# INTER-OFFICE MEMO

DATE: September 11, 2023

FROM: Megan Jones, MCRP - Senior Planner

RE: Project #2023-008767/SI-2023-001056  
Site Plan-EPC Major Amendment, 200 Tramway Blvd. SE

1001565
Smith's
 FOOD & DRUG STORES
#427
 Albuquerque, New Mexico

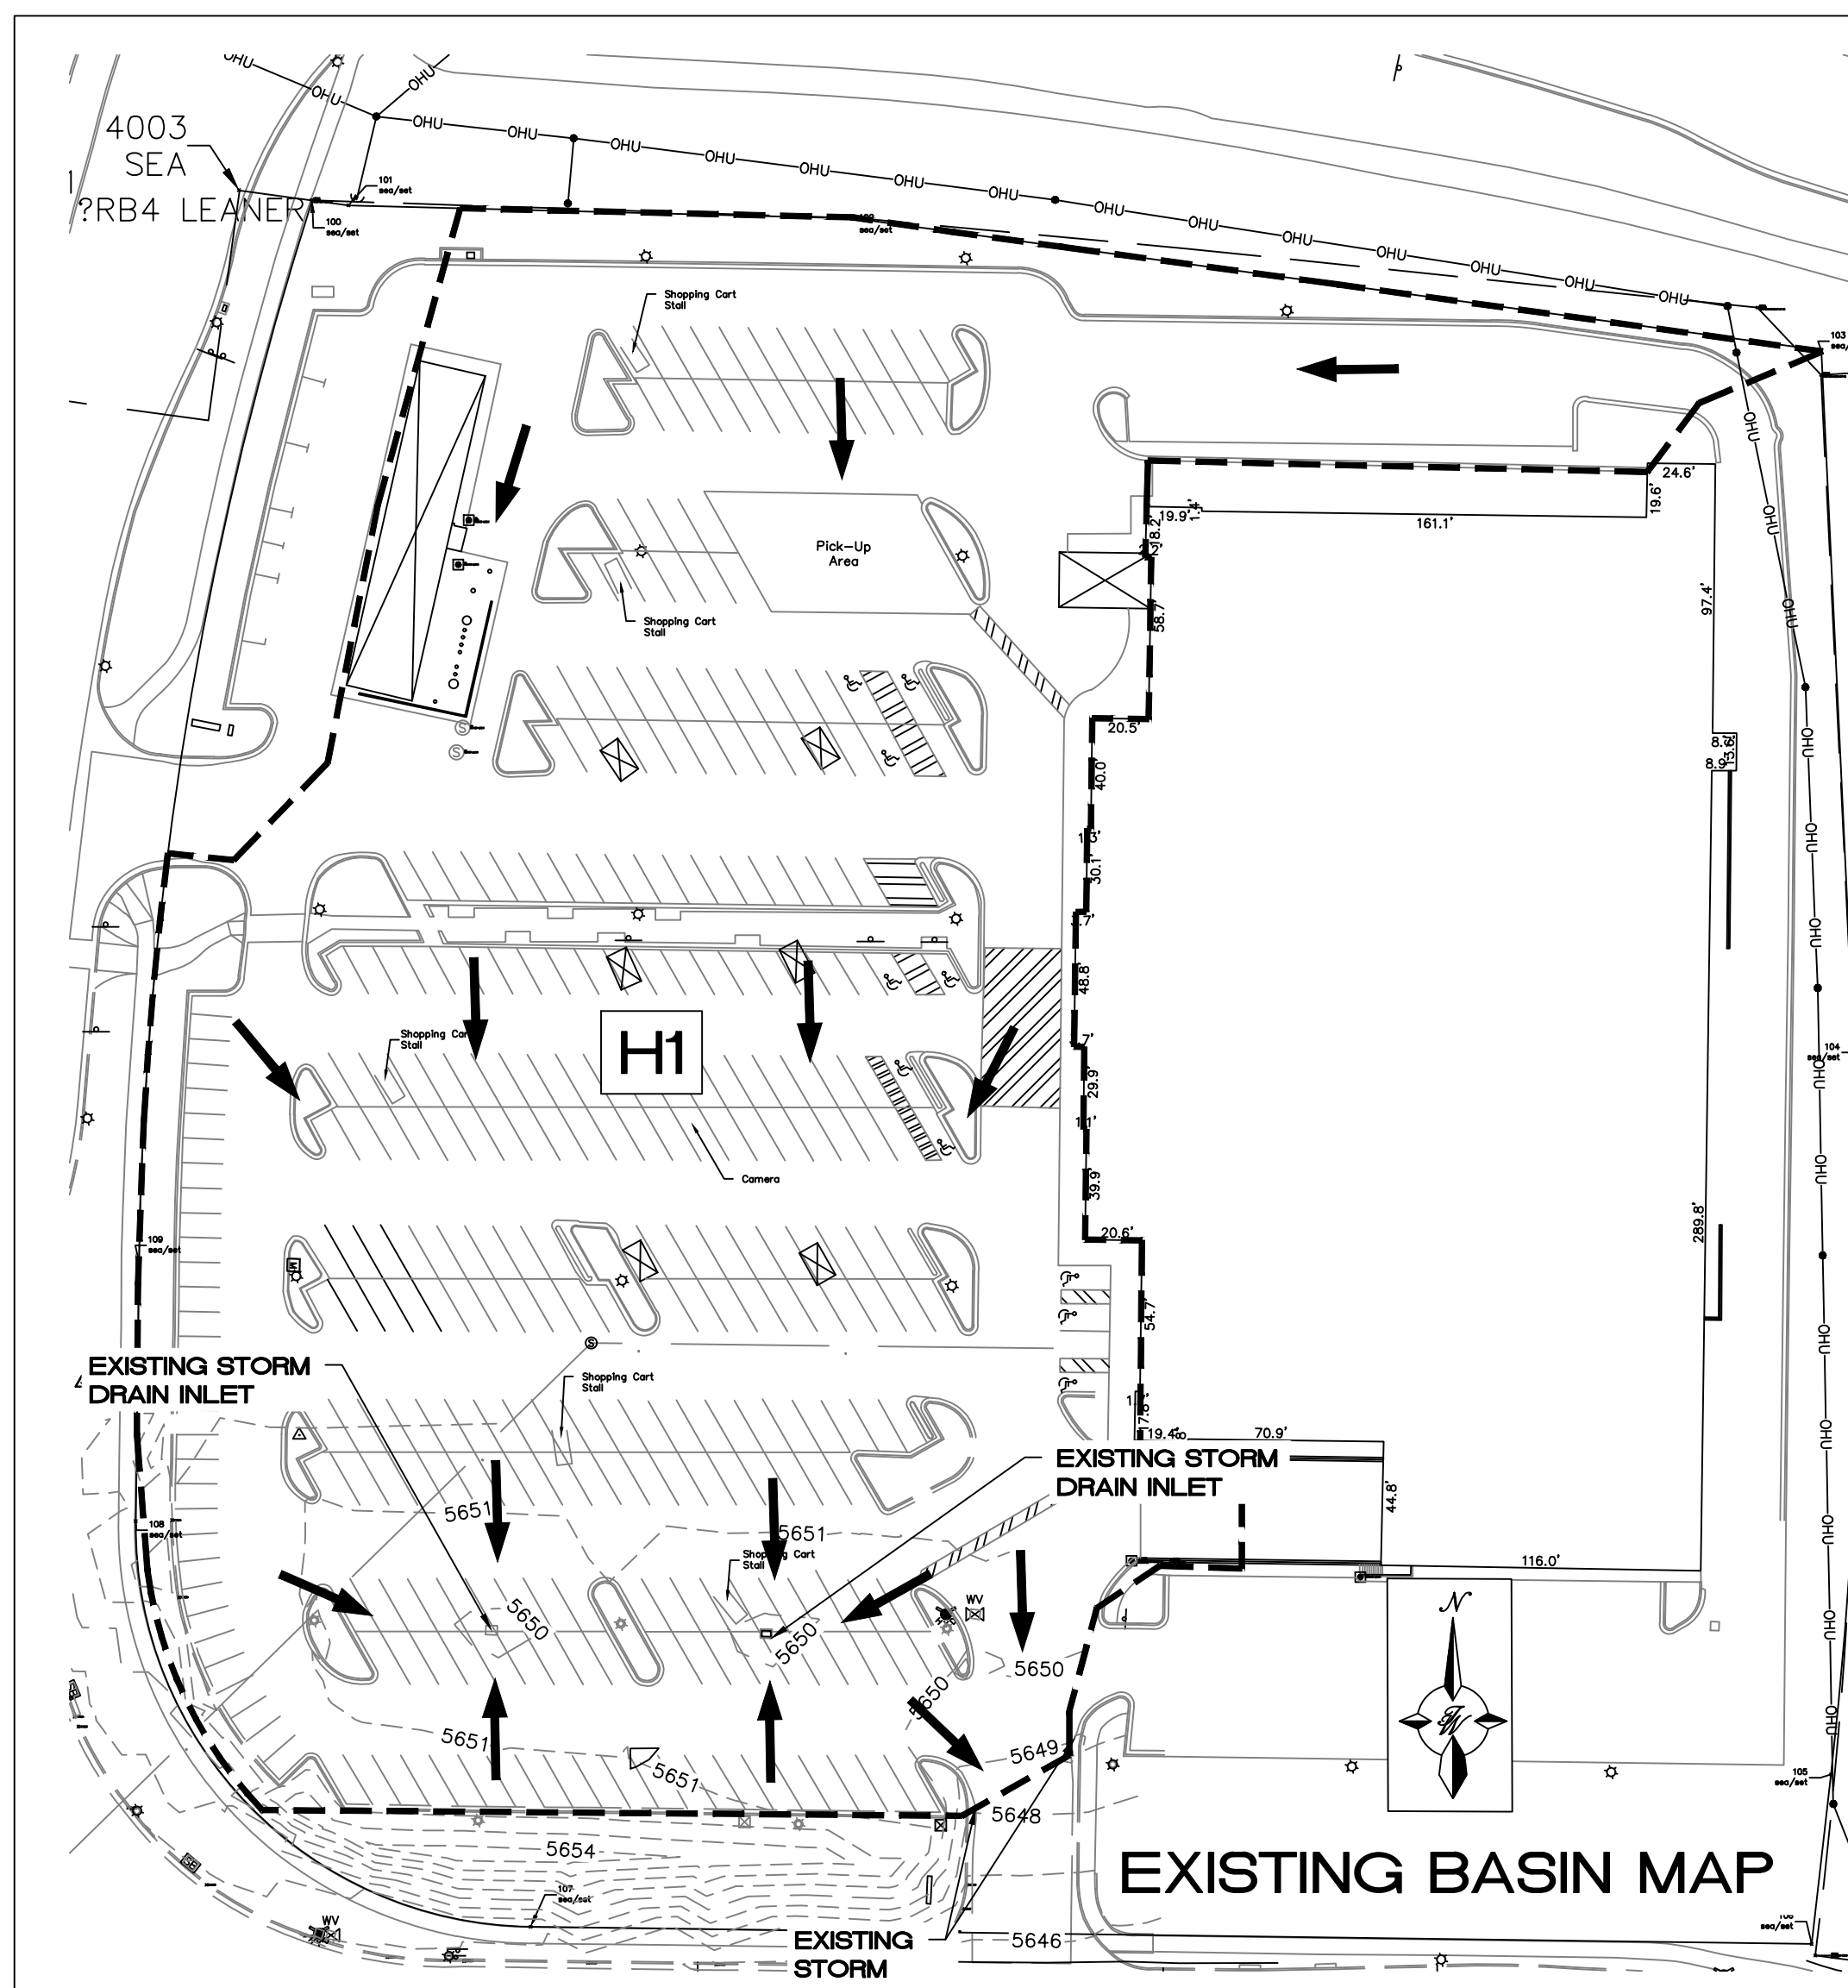
- a. A note shall be added to sheet C1 stating that the EPC approved the requested amendments on 7-20-2023.
  - b. The G&D Plans show exiting and proposed G& D as sheet C3.
3. Condition 4, a: The applicant shall update the Major Amendment sheet to reflect the provided bicycle spaces. This was only included on the Site Plan sheet associated with the request. All amendments shall be reflected on the Major Amendment Sheet.
4. Condition 4, b, 5-11: Satisfied.
5. Condition 12: The applicant shall provide a note on the Site Plan and light pole detail stating that all building surface mount light fixtured will be shielded and downward focused.
6. Condition 13: Satisfied.
